## Viking CCS Pipeline

# 9.47 Applicants Responses to Issue Specific Hearing (ISH) 3 held 17 July 2024

Document Reference: EN070008/EXAM/9.47

Drawing title
**Central Construction Compound
Regulation 5.2 (o)
Application Document Reference 4.10
(Sheet 1 of 1)**

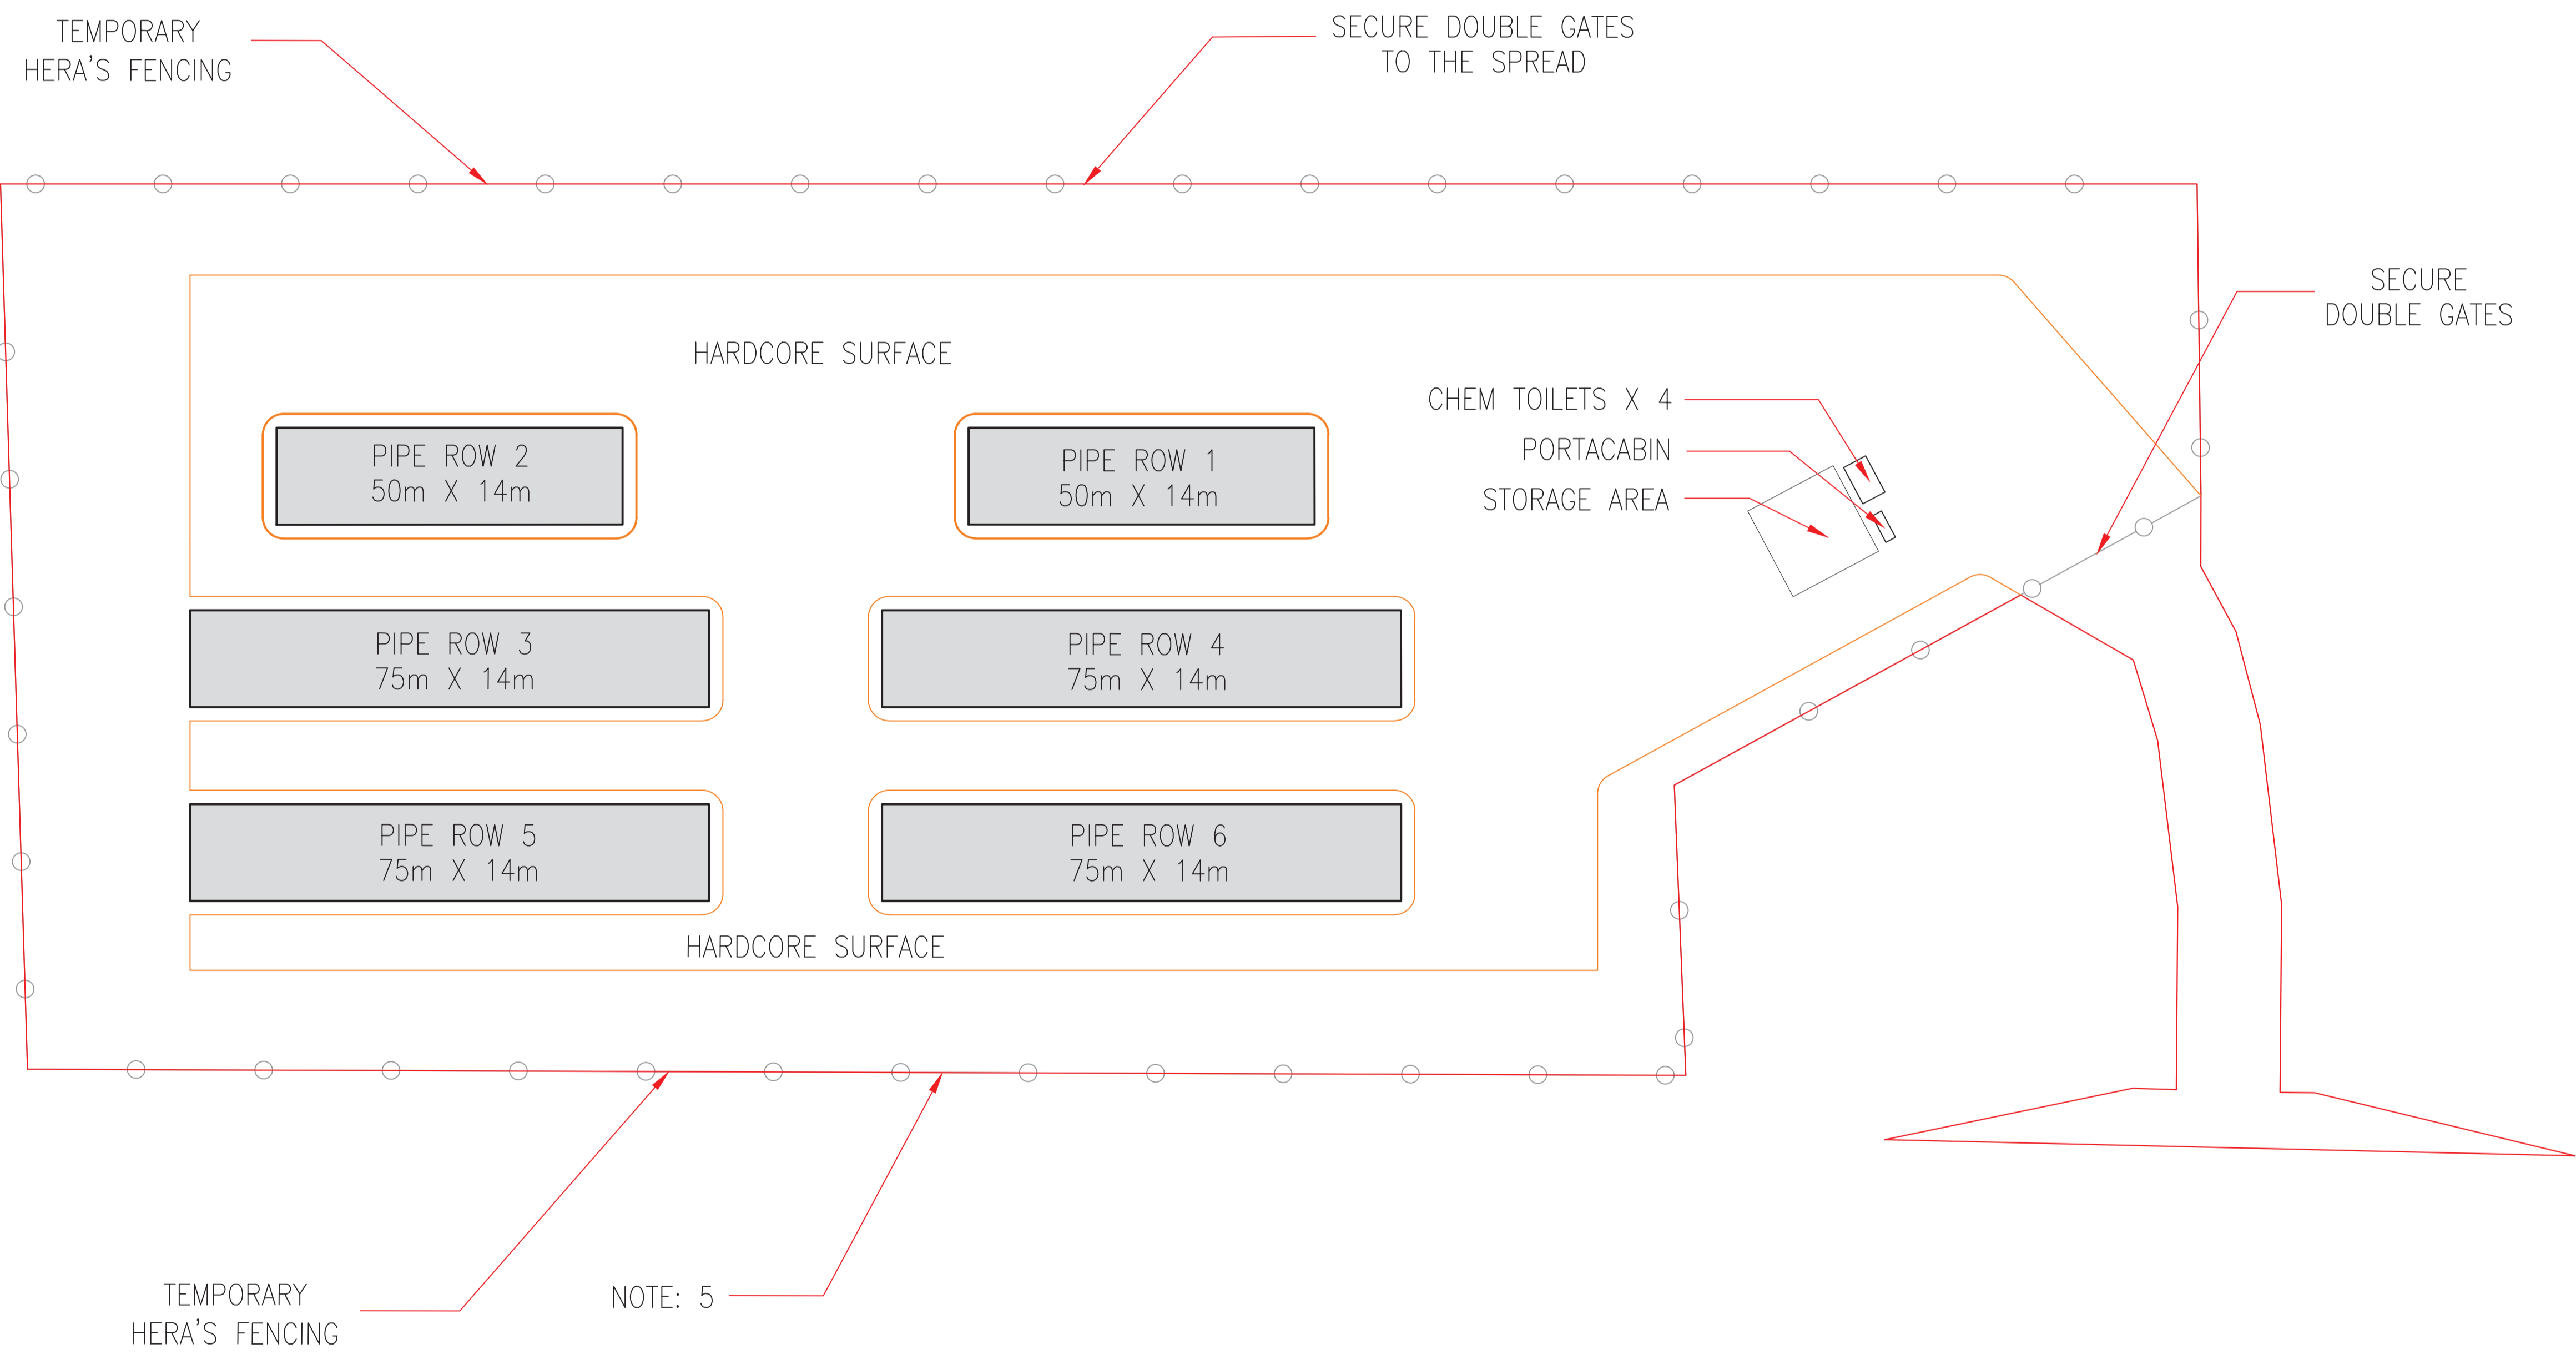
8.	Provide a more detailed response concerning the site selection reasons for the central construction compound positioned in the setting of the Area of Outstanding Natural Beauty (AONB).	A technical note has been prepared outlining the reasons for the selection of the site for the central construction compound. The technical note has been submitted at deadline 4 (document reference: EN070008/EXAM/9.56)

Washingdales Lane
Block Valve Station
(BVS1)
Regulation 5.2 (o)
Application Document Reference 4.14
(Sheet 1 of 1)

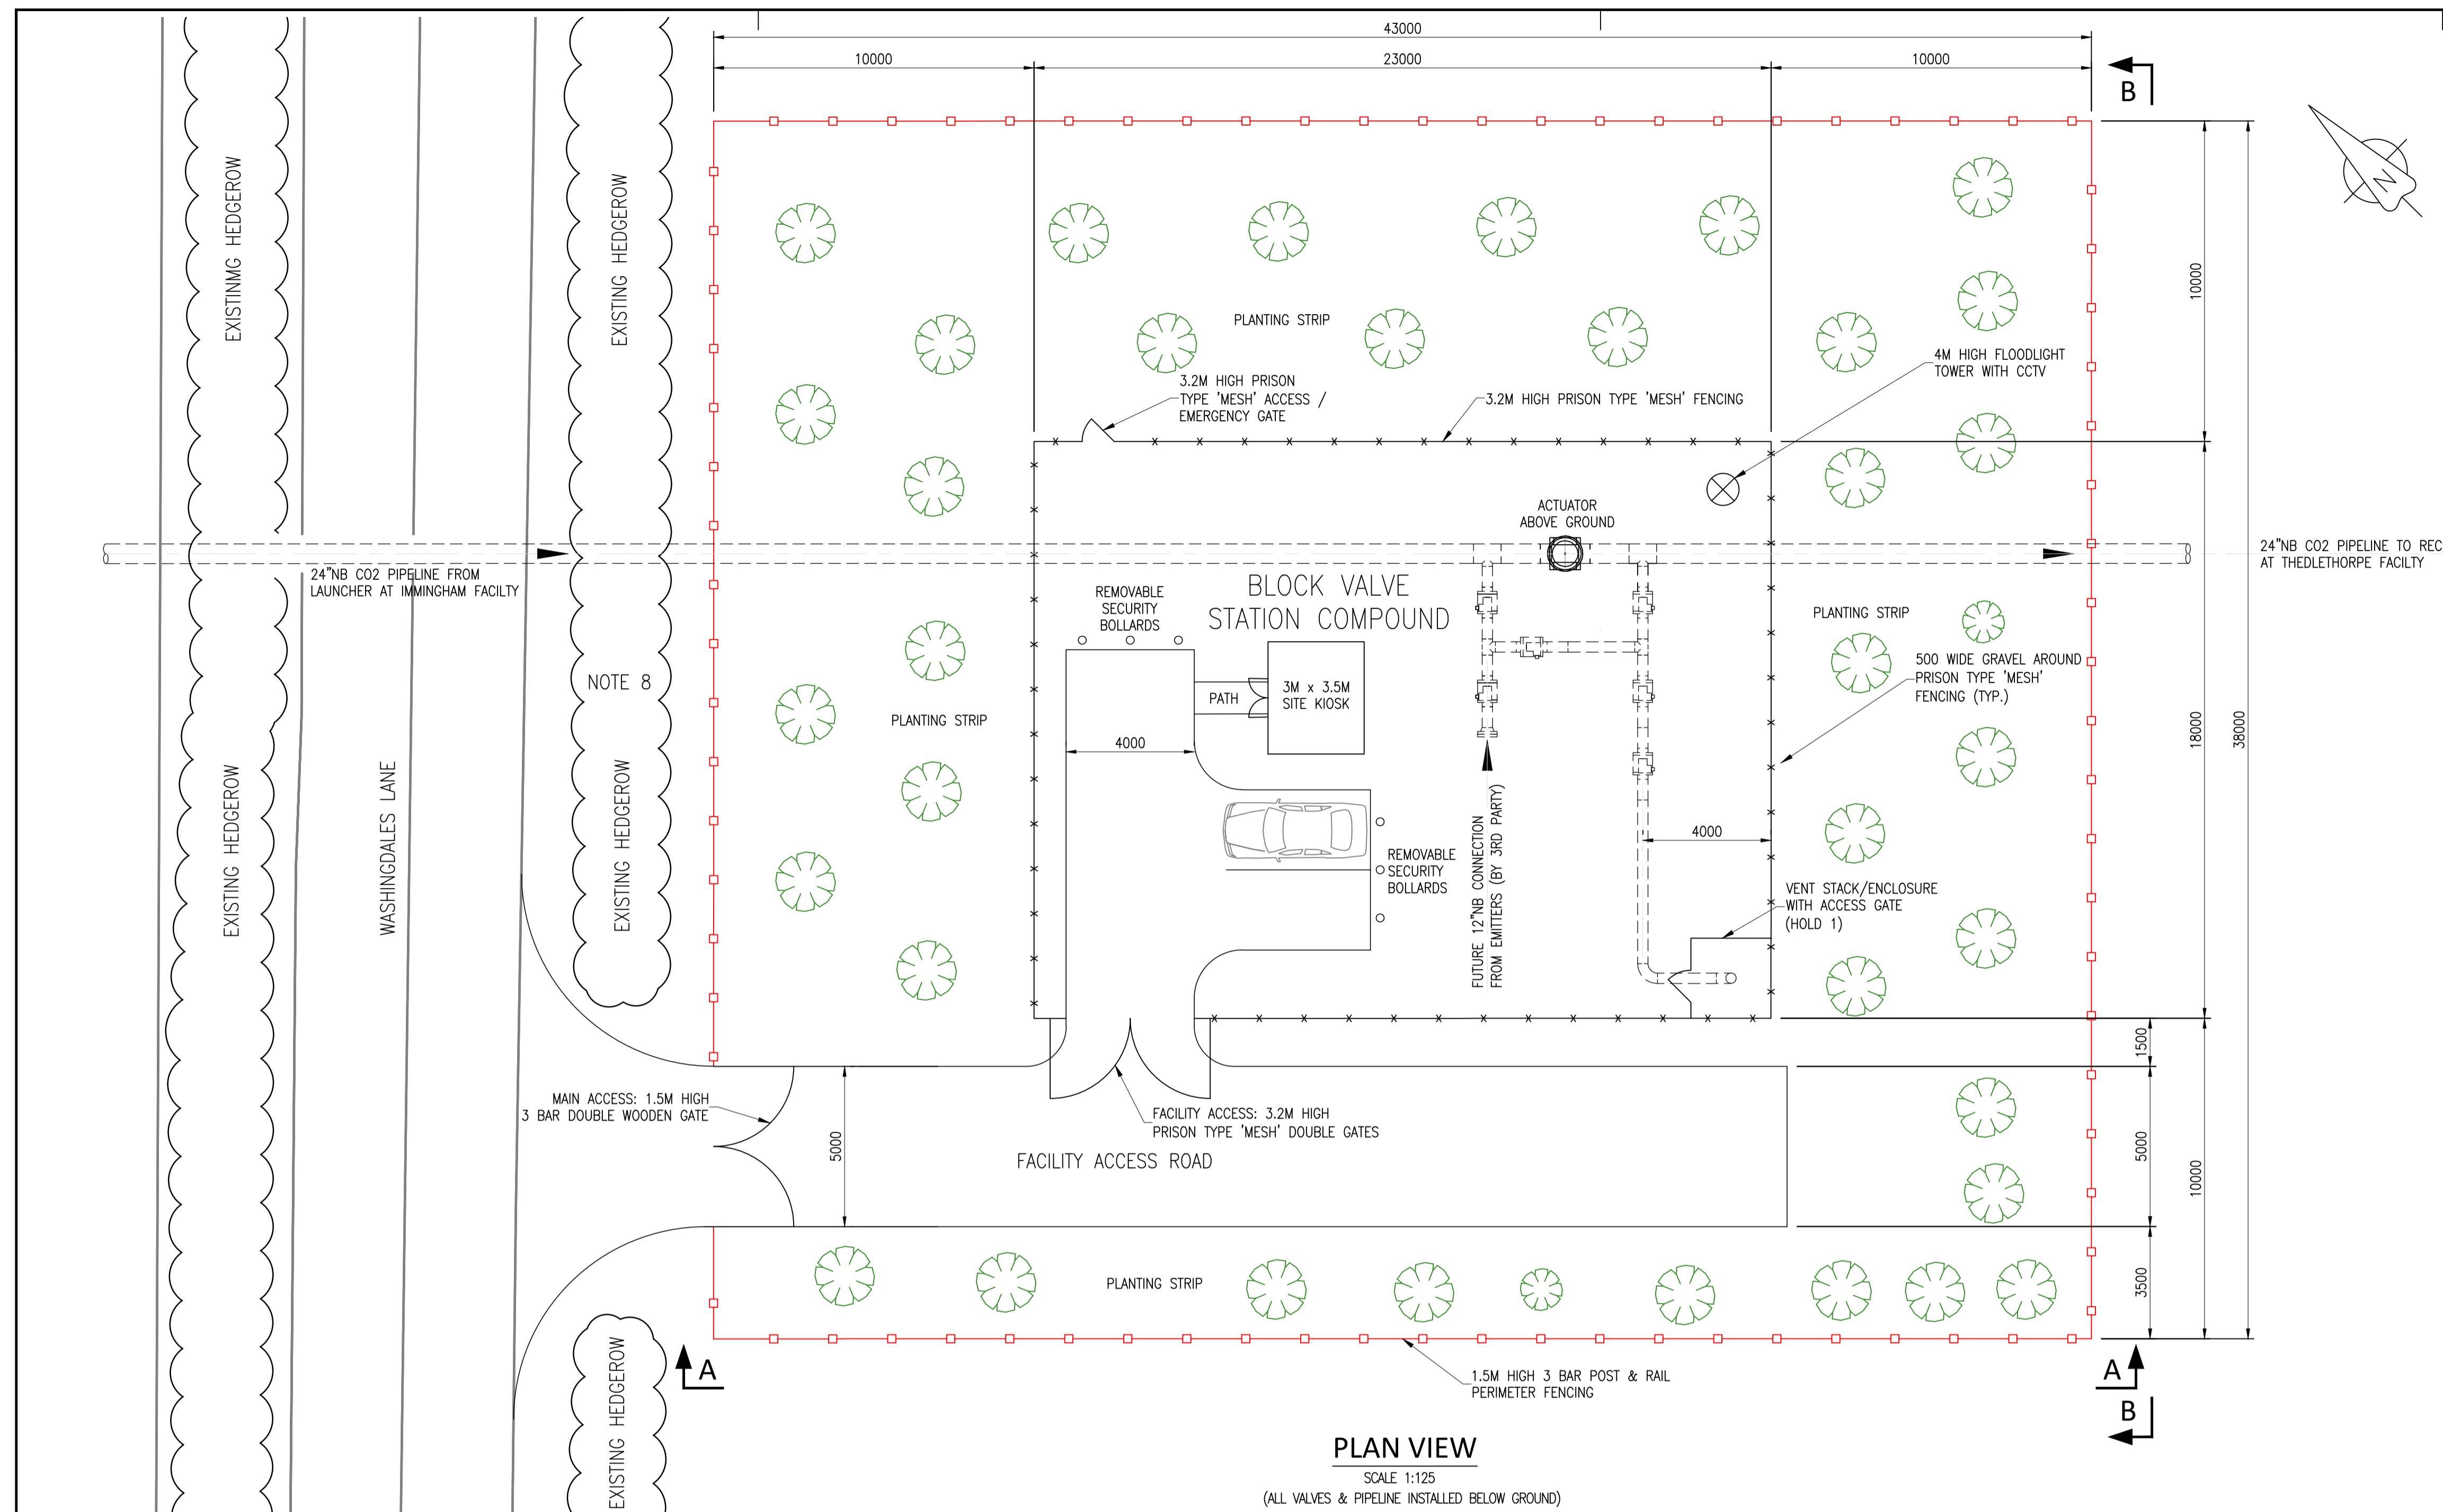
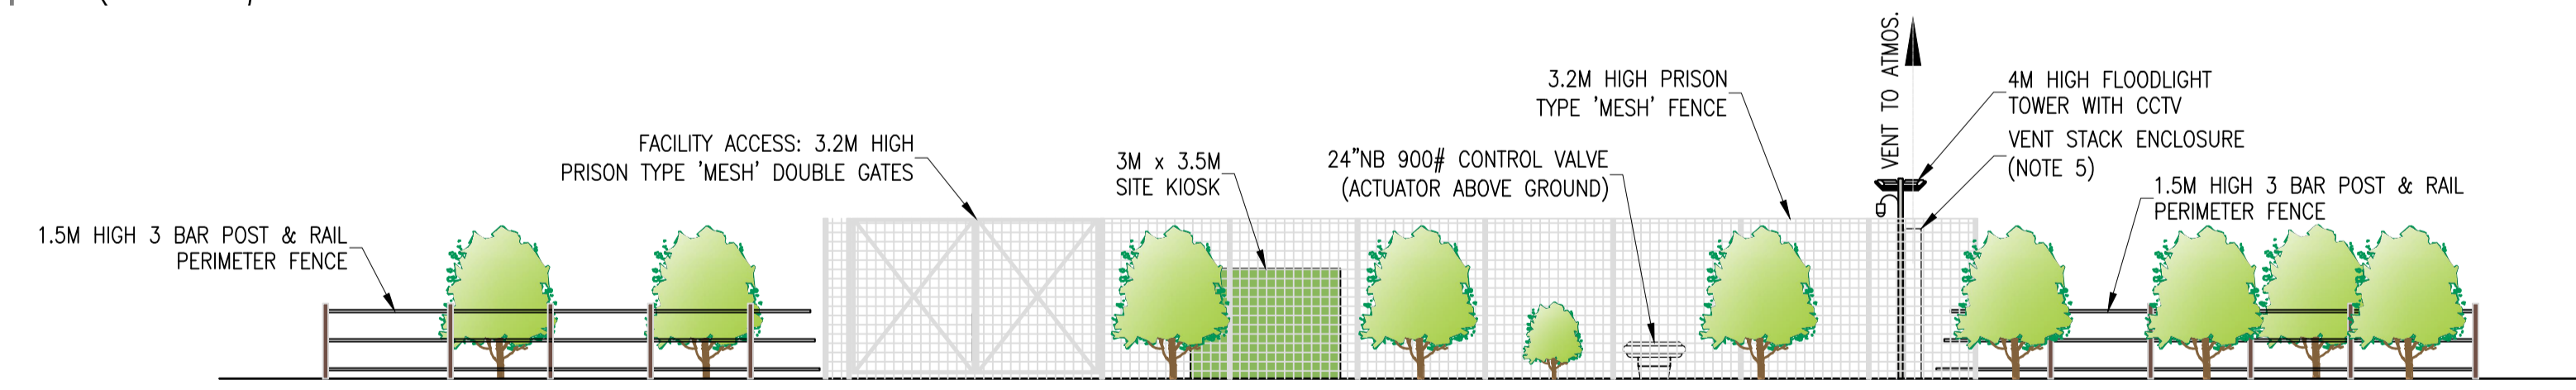
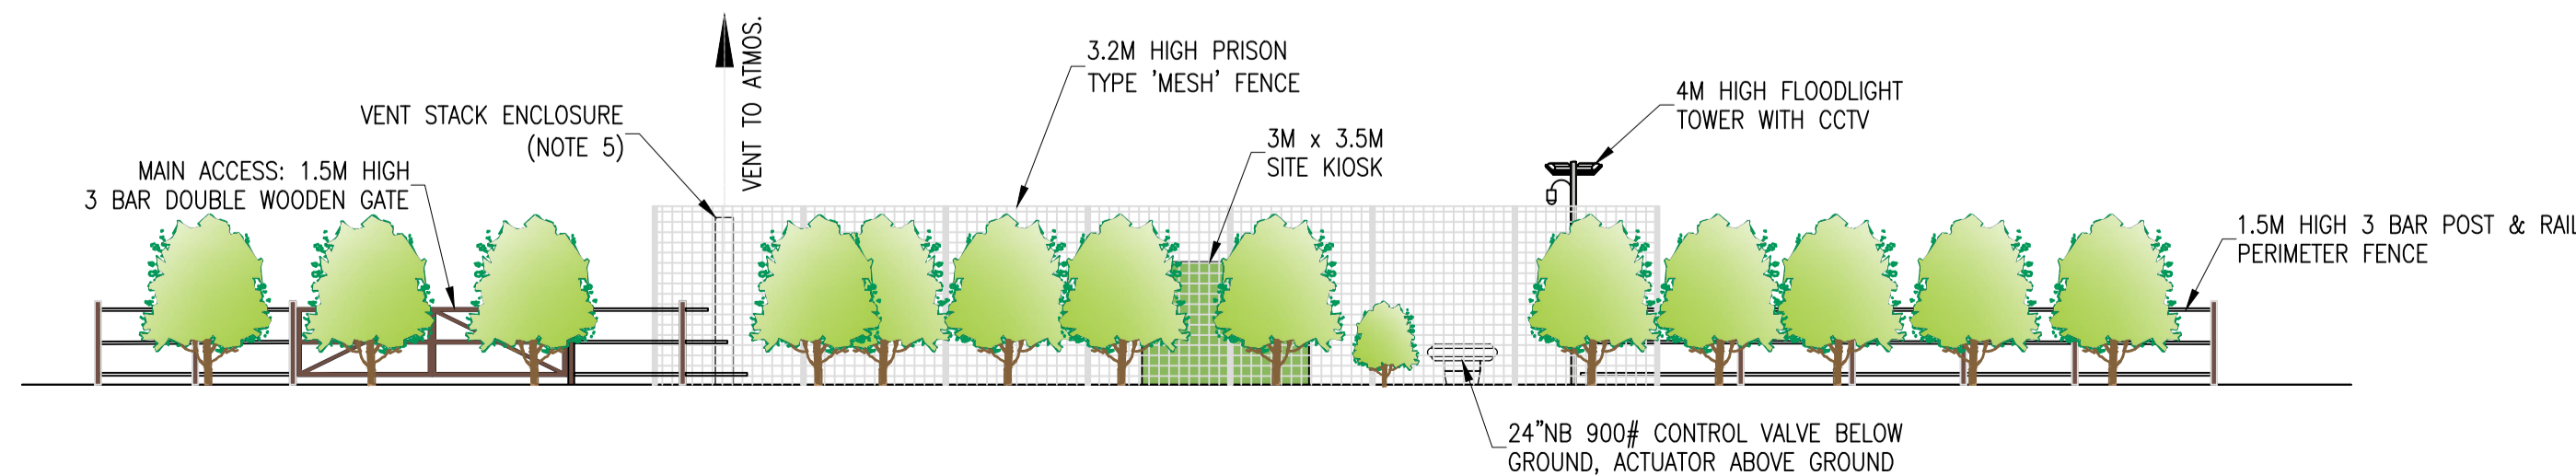
Action Ref.	Applicant Actions Raised in ISH3 17 <sup>th</sup> July 2024	Applicant's Response
13.	Provide updated illustrative plans to be certified showing the Block Valve Stations without the venting stacks.	<p>Updated illustrative plans showing the block valve stations without venting stacks have been submitted at deadline 4:</p> <p>EN070008/APP/4.14 - Washingdales Lane Block Valve Station Plan and Elevations            EN070008/APP/4.15 - Thoroughfare Block Valve Station Plan and Elevations            EN070008/APP/4.16 - Louth Road Block Valve Station Plan and Elevations</p>
